Comments for Planning Application 21/00726/F

Application Number: 21/00726/F

Address: 2 The Parade Shirehampton Bristol BS11 9TS

Proposal: Change of use from A3 (coffee shop) to Hot Food Takeaway (Sui Generis Use).

Ground Floor
Plan as
Proposed

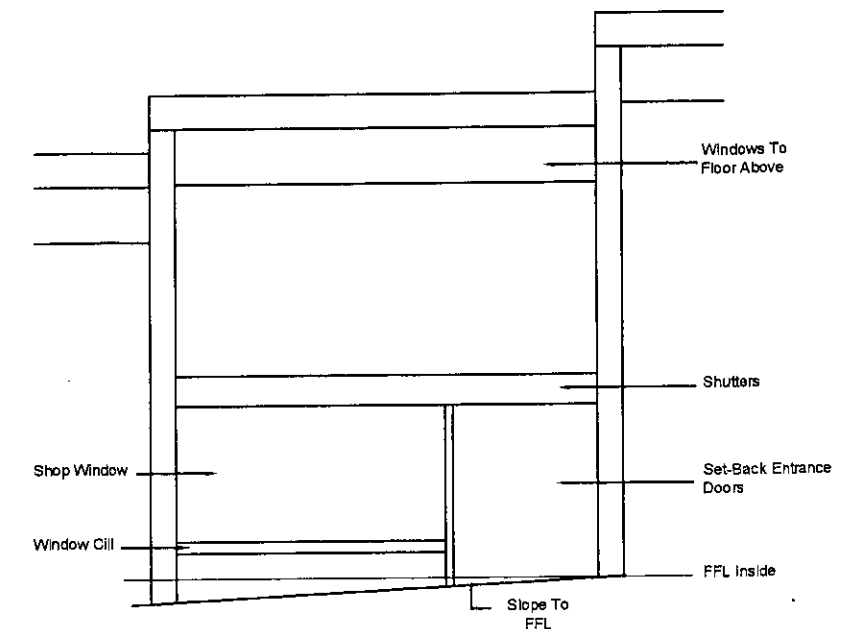
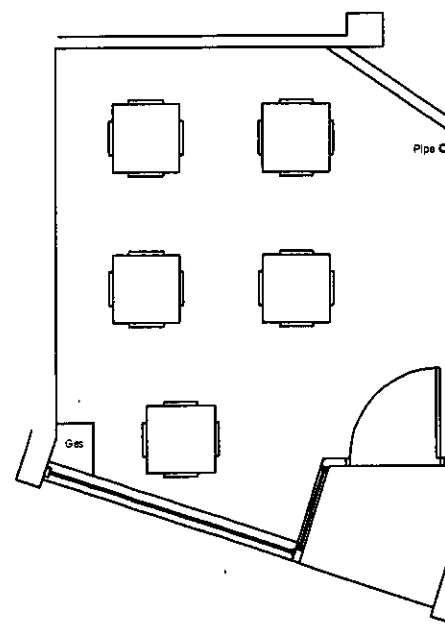
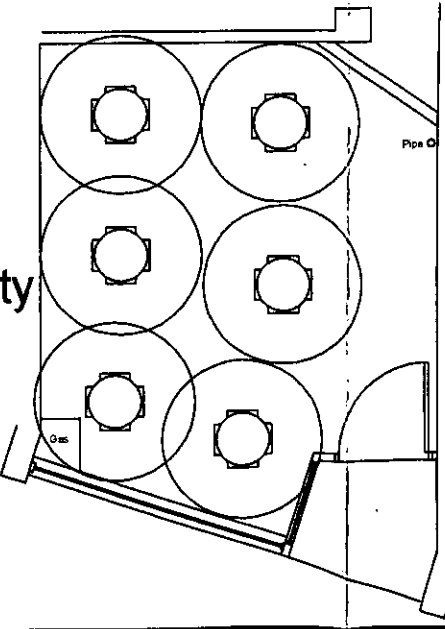
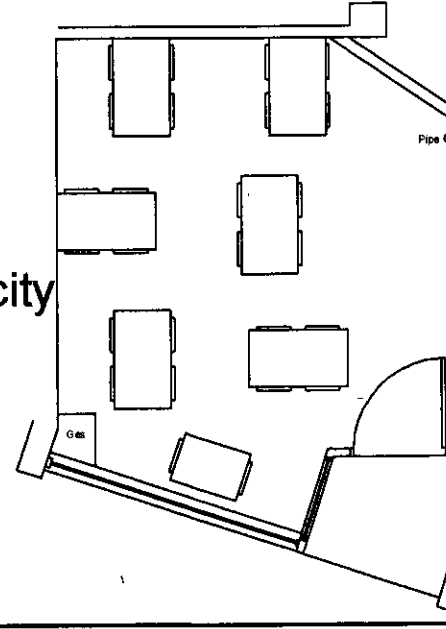
The submitted document is the same one as was submitted years before when the change of use to a Café was Granted. The Application is stating that 'nothing is changing' but the new request is

for a Take Away yet it shows the Seating Plan as a Café? A Take Away with this level of seating will have a deleterious effect of noise and disturbance to the area

If the café seating arrangements and layout are to remain, we are concerned that the property will lack Focus. Being open late at night it will become an unsuitable gathering place and lead to more of the antisocial behavior problems that we have in Shirehampton
